From: Sarah Burrow <Sarah.Burrow@arun.gov.uk>
Sent: 03 November 2020 15:57
To: Planning.Responses <Planning.Responses@arun.gov.uk>
Cc: Maria Tomalova <Maria.Tomalova@arun.gov.uk>
Subject: RE: Planning Consultation on: FP/184/20/PL

Further Engineers Comments Regarding Surface Water Drainage

Application No:	FP/184/20/PL
Registered:	2nd October 2020
Site Address:	Rear of 7 Middleton Road Felpham PO22 6BL
Grid Reference:	496183 100310
Description of Works:	Demolition of existing garage/outbuilding & construction of a pair of semi-detached houses & associated works. This site is in CIL Zone 4 & is CIL Liable as new dwellings.

Ground Floor Plan

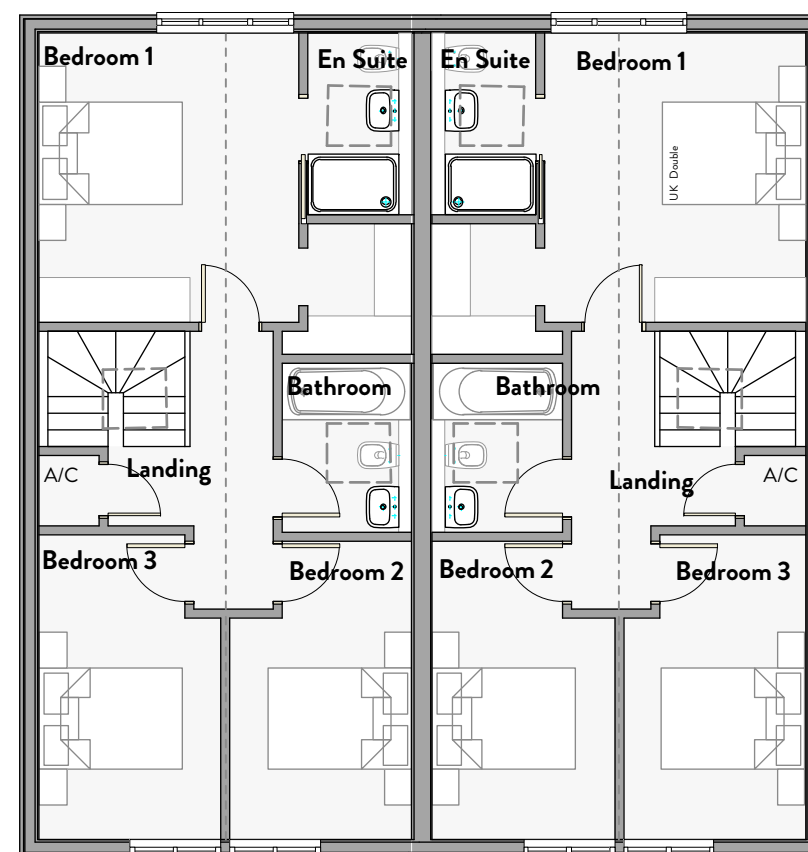
1. No impermeable area plan has been provided. The impermeable area used in the calculations is 80m^2 , it is unclear whether this is per soakaway or for the two combined. According to the proposed floor plans each proposed semi-detached property will be 52.5m^2 internal floor area, totalling 105m^2 not including the garden room which also needs to be accounted for in the design. It is assumed that the 80m^2 is for the single property, however this is unclear and needs to be clearly shown on an impermeable area plan.

TYPICAL AQUACELL SOAKAWAY
(pedestrian and car/light van loading only).
(Scale 1:20)

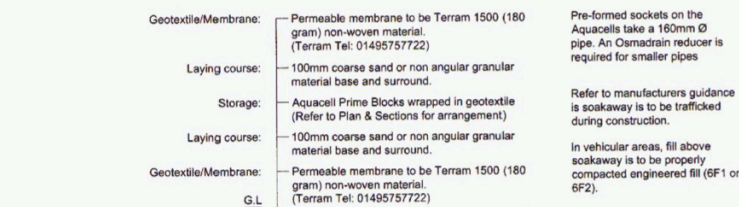
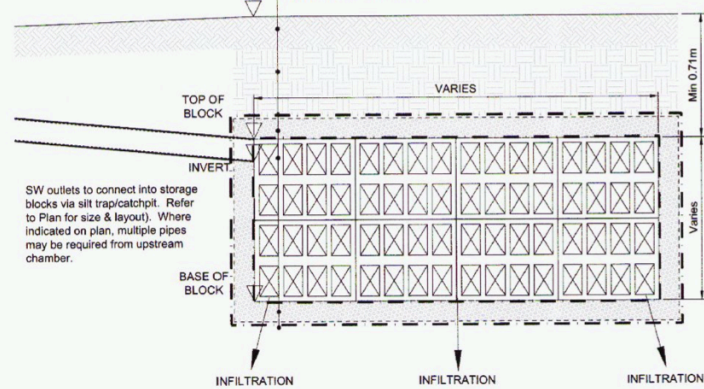
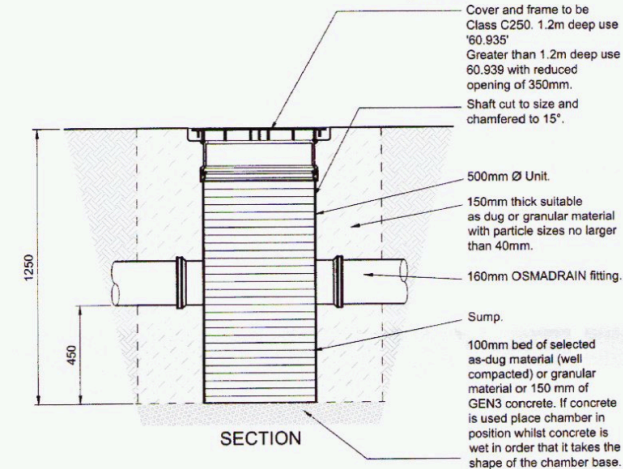
6. Linked to point 5; the soakaway construction details show a minimum cover depth of 0.7m, and the crates are 0.4m depth, yet depth of crates is stated on the drainage checklist as 0.9mbgl. With groundwater evidenced at 1m below ground level the crates must be kept at 0.9mbgl as a minimum. The construction detail will need to be amended to reflect this. If necessary the specified crates will need to be changed to ones that are suitable at shallower depths in vehicular areas.

Title:
AQUAFLOW PERMEABLE PAVING LAYOUT
FOR PARKING AREA AND ACCESS ROAD

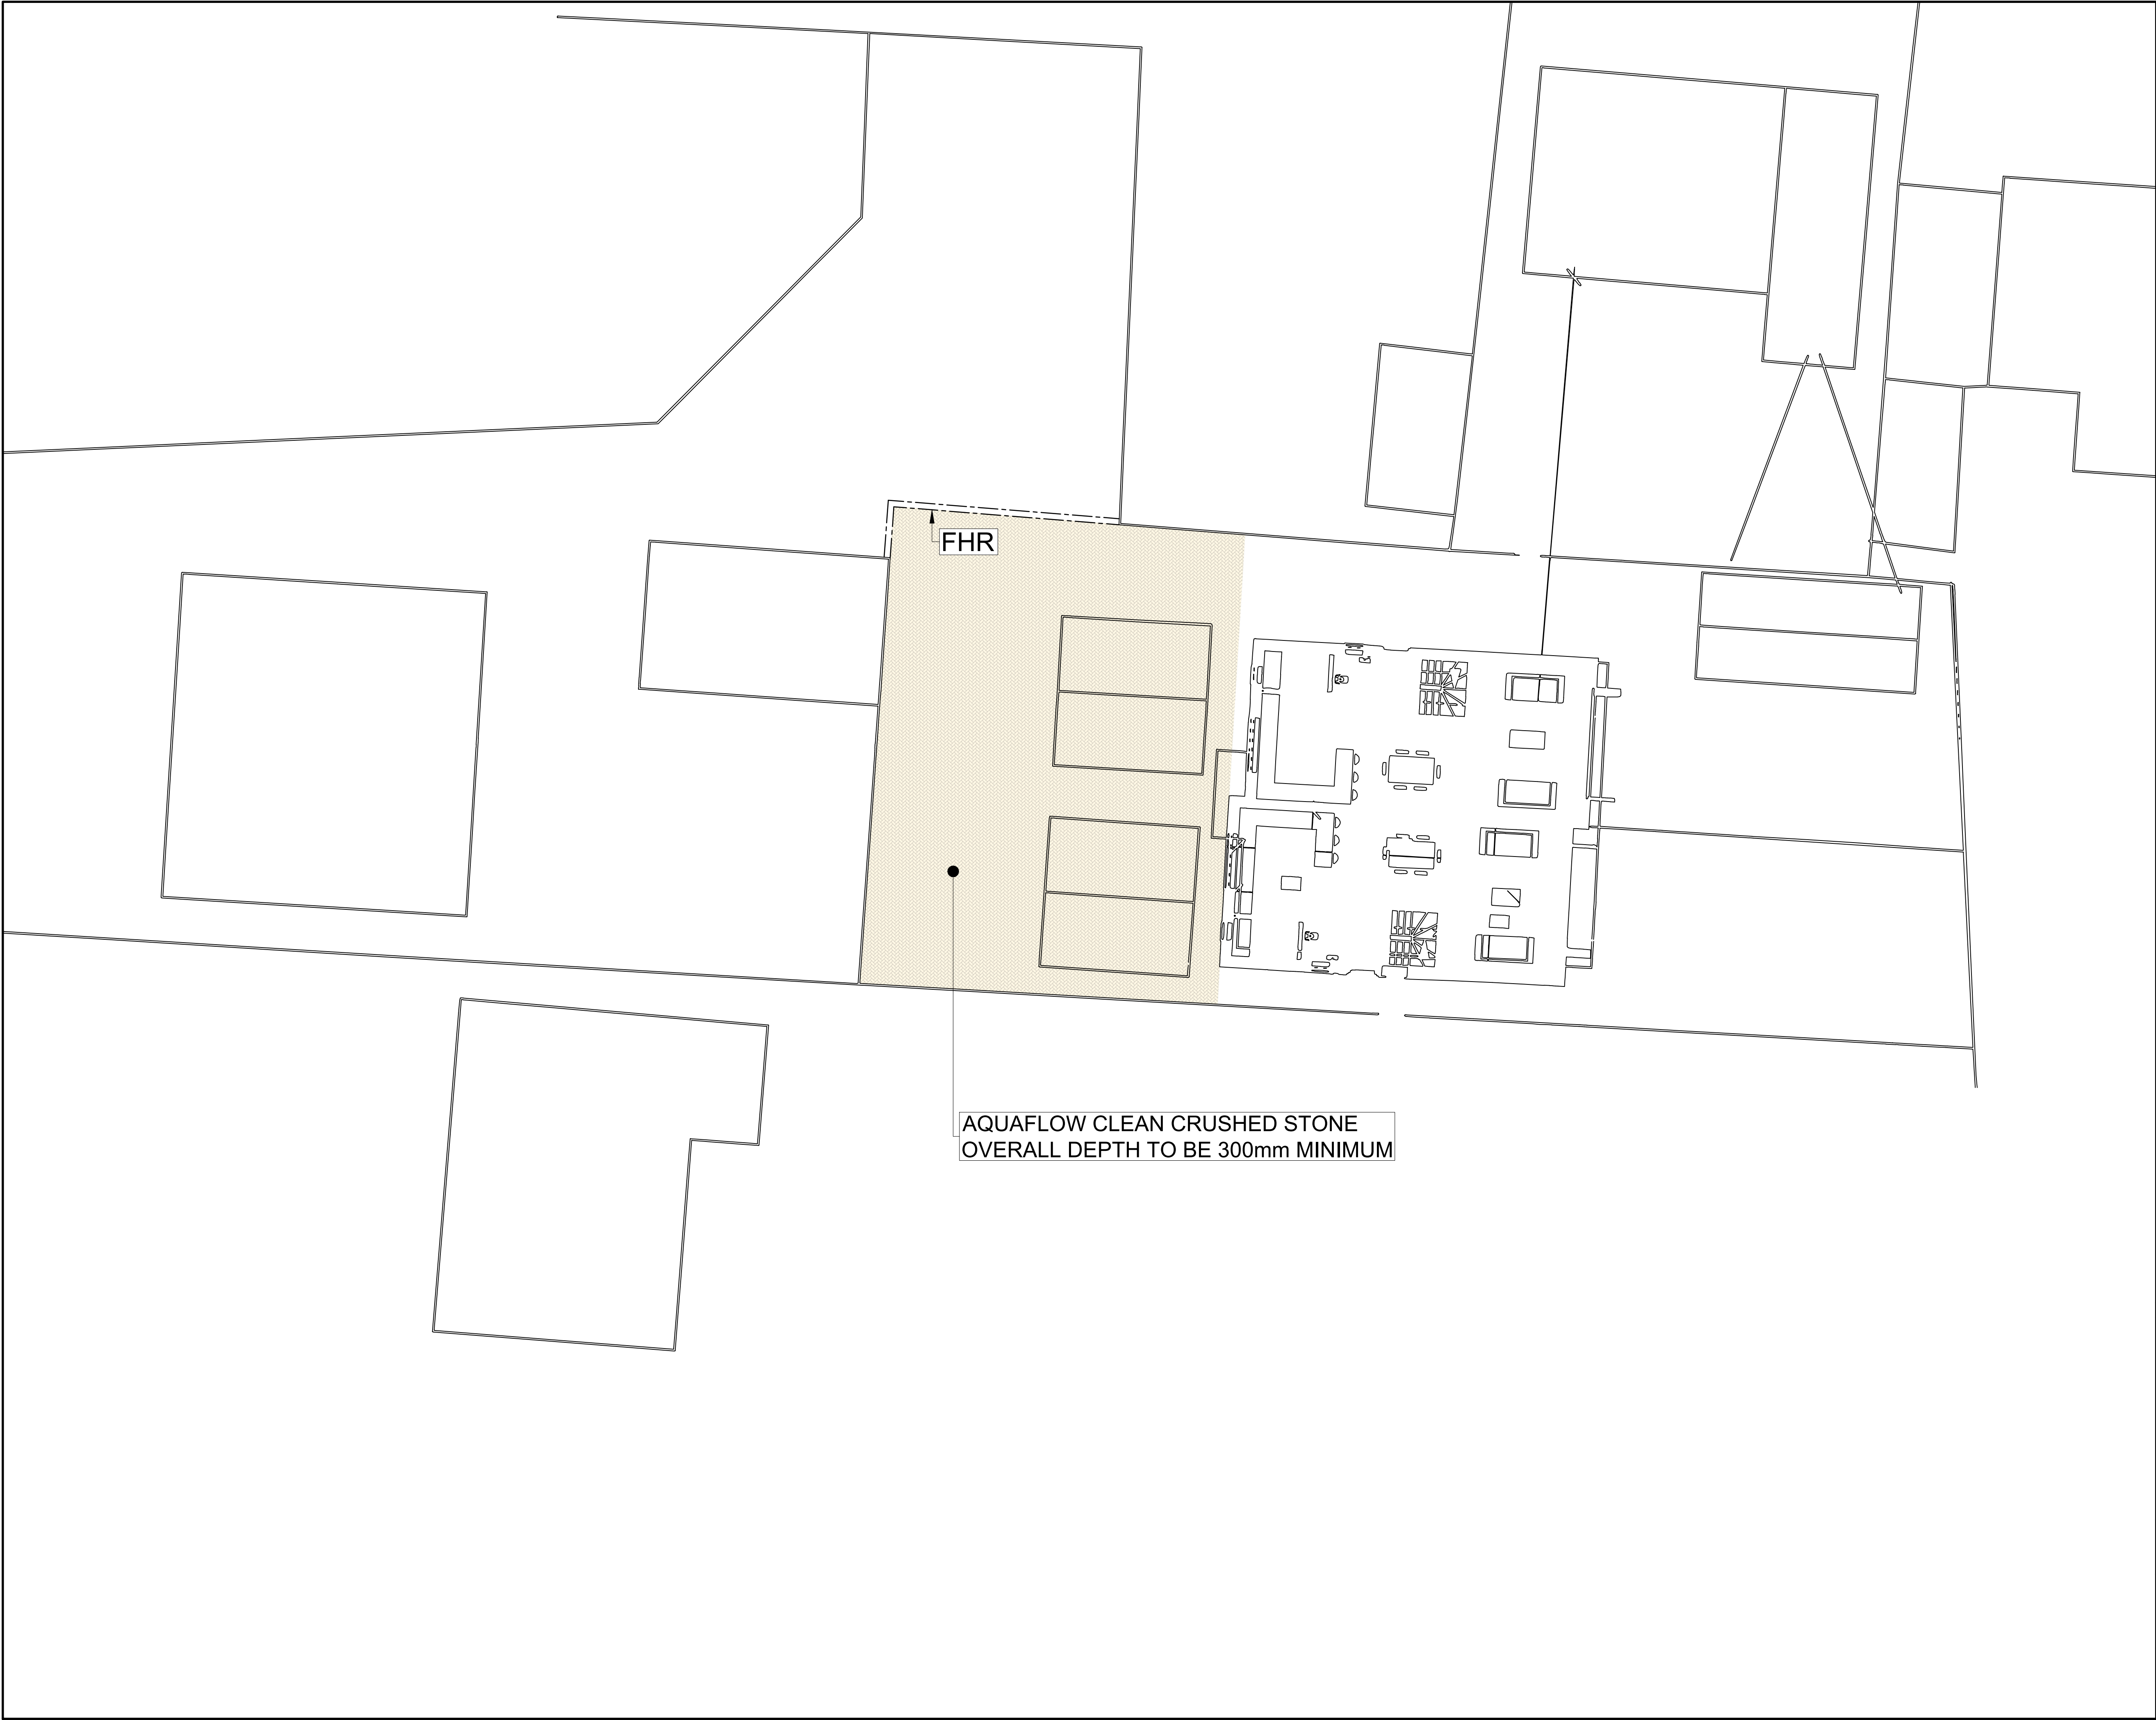
5. Permeable paving is shown on a separate drawing to the drainage layout without consideration of how it will interact with the soakaway below. It may be worth considering a permeable paving solution which the first semi and garden room can drain into via diffuser units. At a minimum the permeable paving should be detailed on the Drainage Plan and 'Clean Crushed Stone' will need to be specified as Type 3 reduced fines or 4/20 or similar to be suitable for the engineered fill. A construction detail will also need to be supplied to show the layers from the block pavers to the bedding layer of the soakaway crates.
